From: Rodenbeck, Jay B.
Sent: Tuesday, September 29, 2020 11:54 AM
To: Gomez, Angela J.
Cc: Gould, Maggie S.
Subject: FW: [#2020013] Wintergreen Apartments (PR-2020-004030)

From: Rodenbeck, Jay B. [<mailto:jrodenbeck@cabq.gov>]
Sent: Tuesday, September 29, 2020 11:30 AM
To: Richard Stevenson
Cc: Gould, Maggie S.
Subject: Wintergreen Apartments (PR-2020-004030)

Subject: PR-2020-004030

Conceptual Landscape Plan

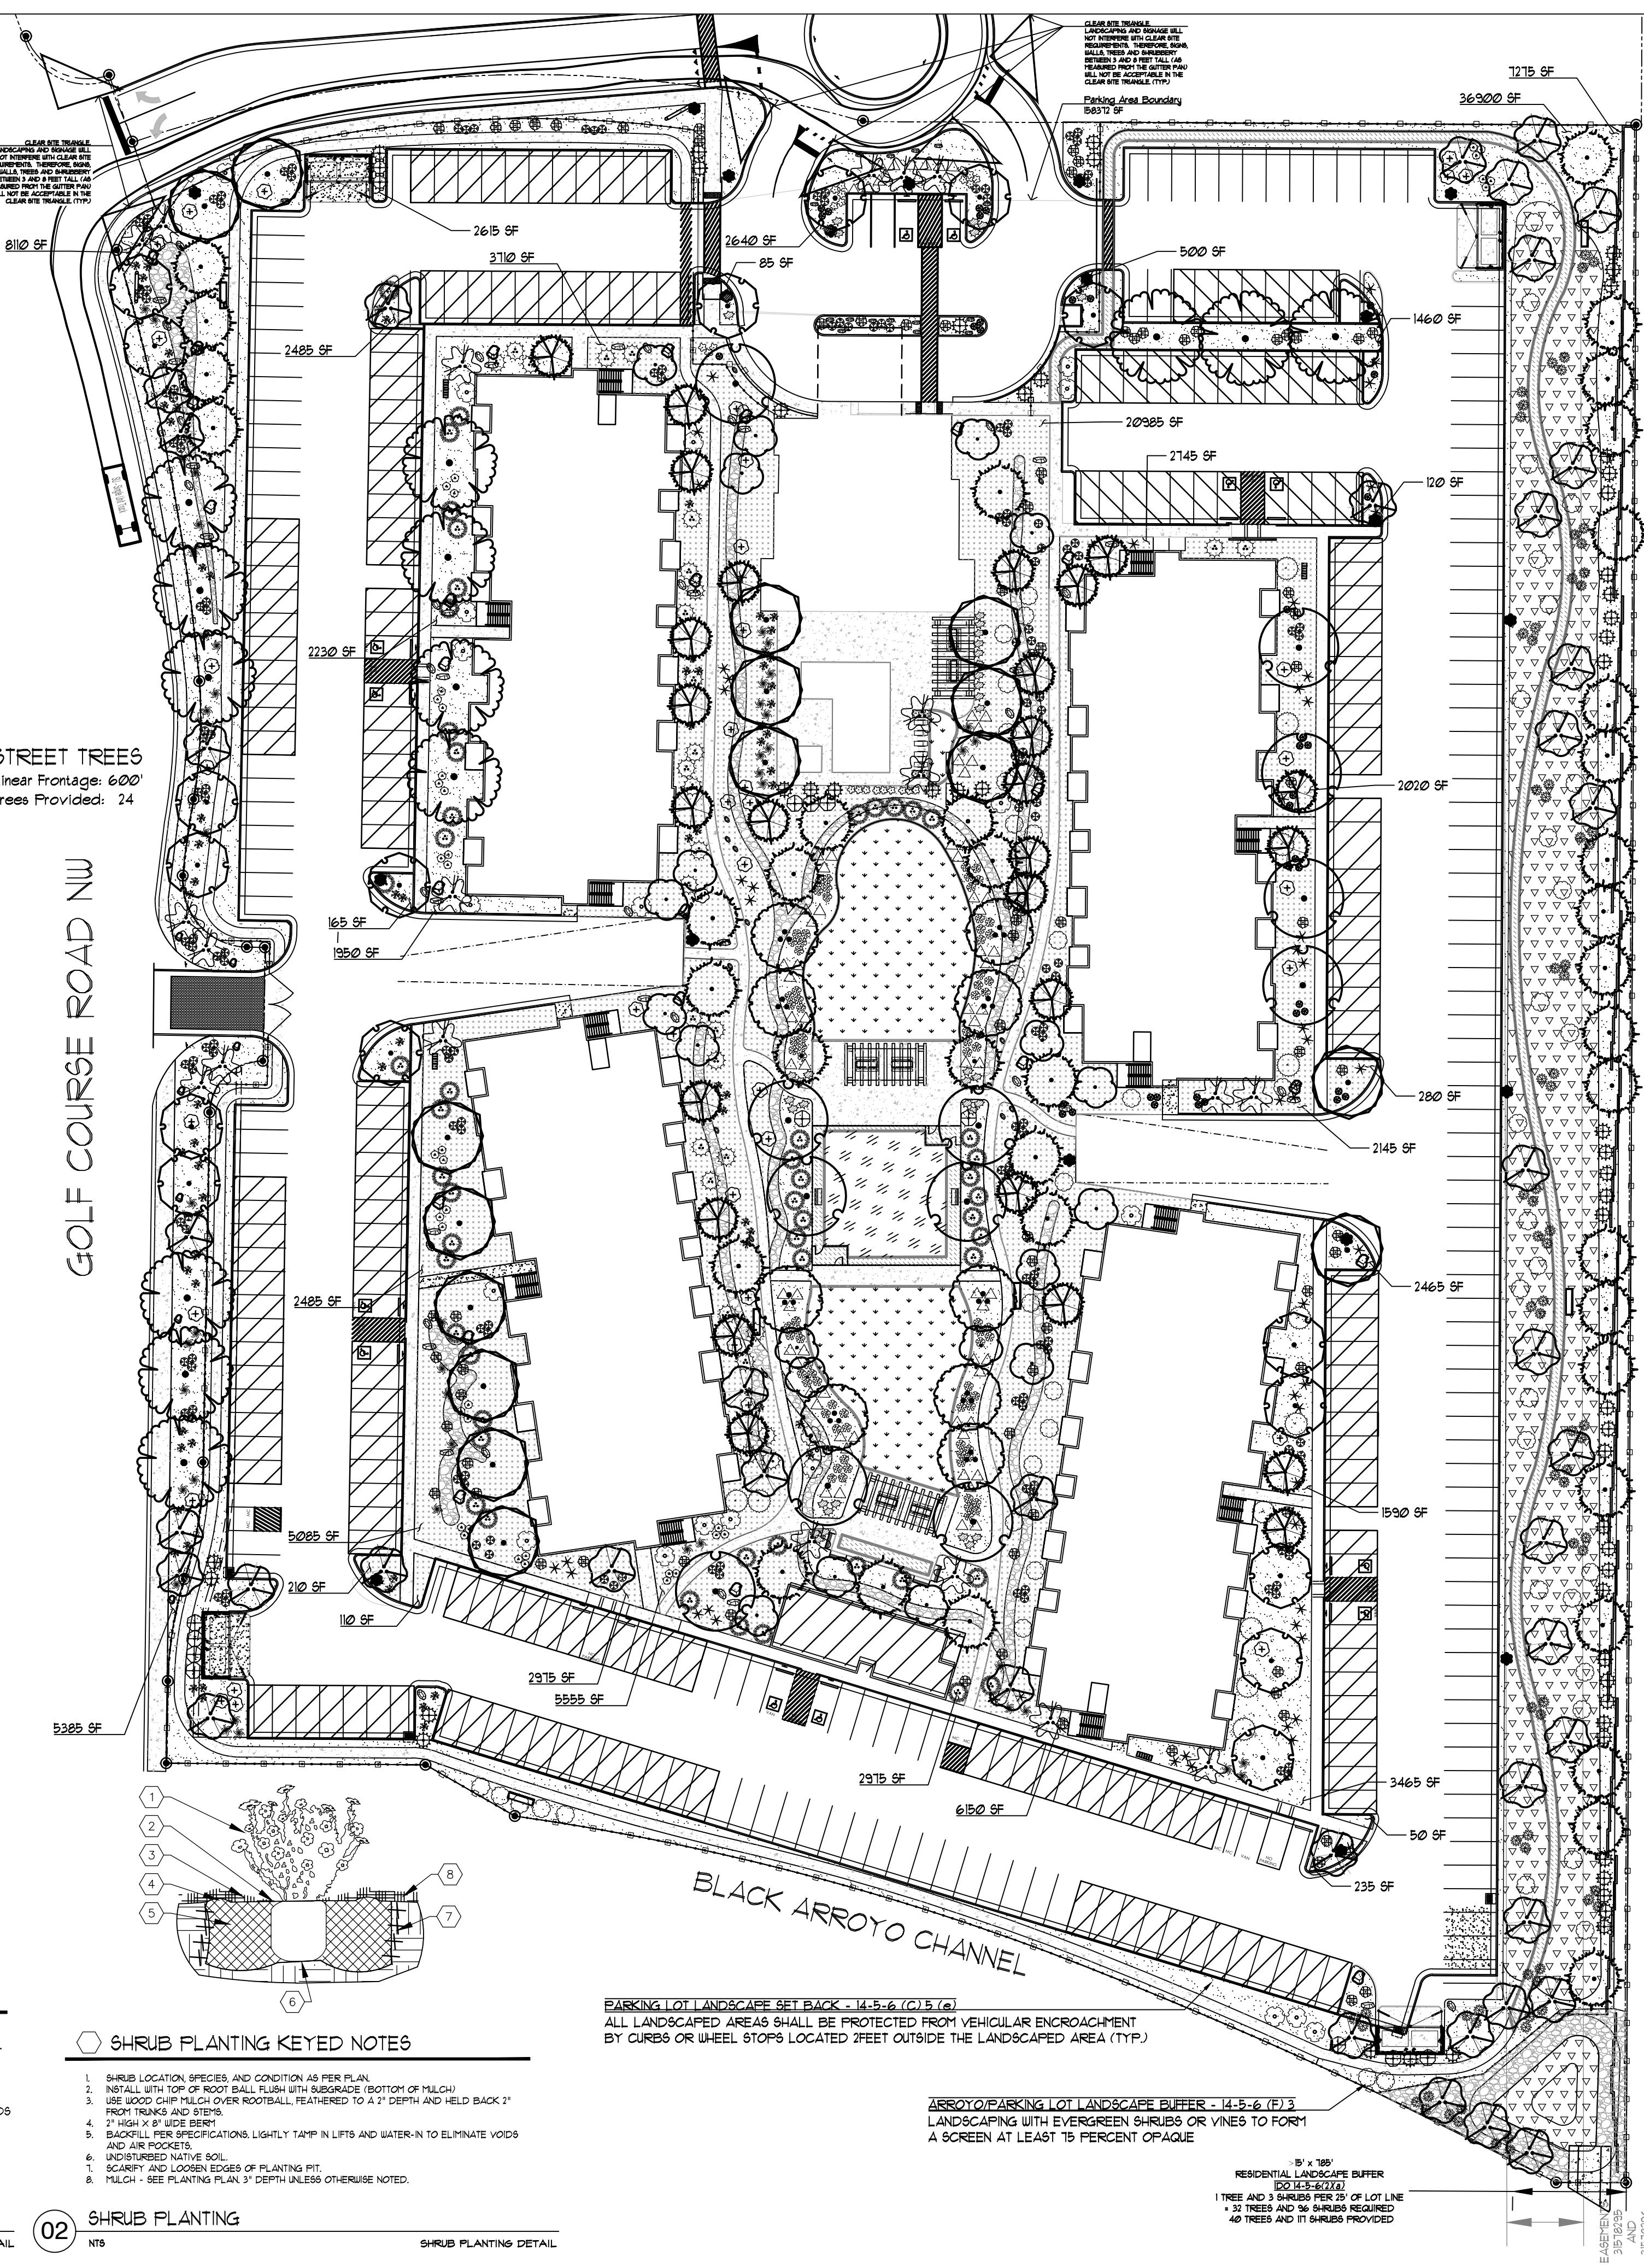
We do not have a record of your response the request below to consider maintaining the existing vegetation between the existing subdivision wall and your wall. If you are able to maintain this vegetation, then this should qualify as a landscape buffer area.

The Seven Bar neighborhood comments received on 9/28/20 are questioning what can be placed in the landscape buffer that is the 15 feet immediately adjacent to their homes. We need you to clarify what will be immediately adjacent to the existing subdivision wall.

Staff was wondering for the apartments at Golf Course and Black Arroyo (PR-2020-004030) if you have received Water Board approval yet? Also, staff has some ideas regarding the natural shrubbery against the residential wall of the 7Bar neighborhood to the east, and some pictures are attached of the shrubbery.

Planning staff feels that a break in the shrubs is about 5-8 feet from the residential wall and is somewhat continuous. Staff feels that this would be a perfect place to put the wall, allowing it to meander.

We discussed with the landscape designer, and below are his comments. Considering these comments, and considering the grading of the site will be ± 1 -2-ft in difference from the existing grade today, we will remove the existing shrubs/vegetation and shall replace with new plating along the buffer area, as its reflected in the landscape plan.

Per 5-6(E)(2)(a) the 15-ft landscape buffer is provided with landscaping per the requirements, and per 5-9 we have the 50-ft buffer before we start the parking area which has shrubs, and smaller plant species scattered throughout.
